Goulburn Mulwaree Council
Locked Bag 22
Goulburn NSW 2580

7 December 2018

**Subject: MP 06_0074 MOD 5
Peppertree Quarry – Modification 5**

Figure 2: Project Layout

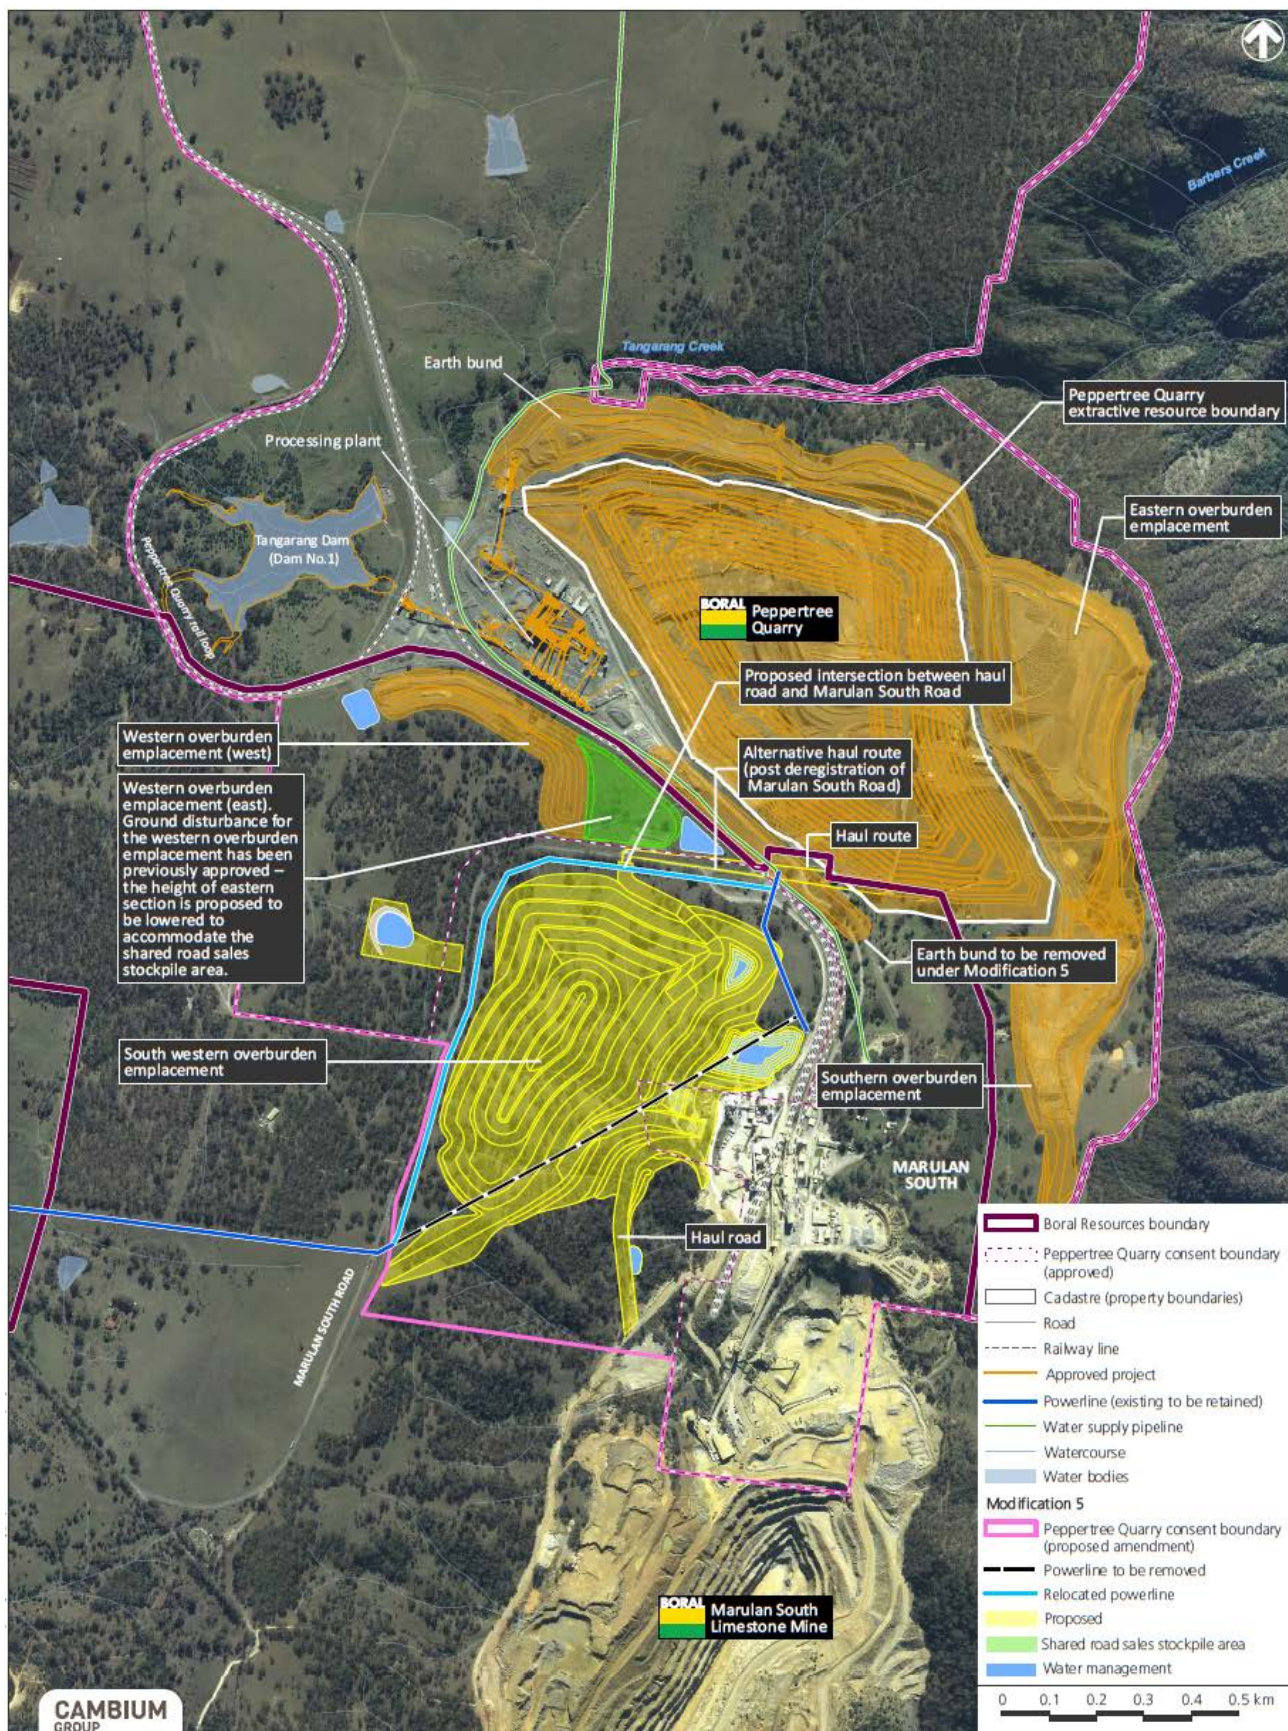
The modification includes a proposal to construct a new haul road from the pit to the south-west overburden emplacement area.

If the road closure permits are not finalised before this road is operational the haul road will conflict with a public road (Refer Attached, Figure 2).
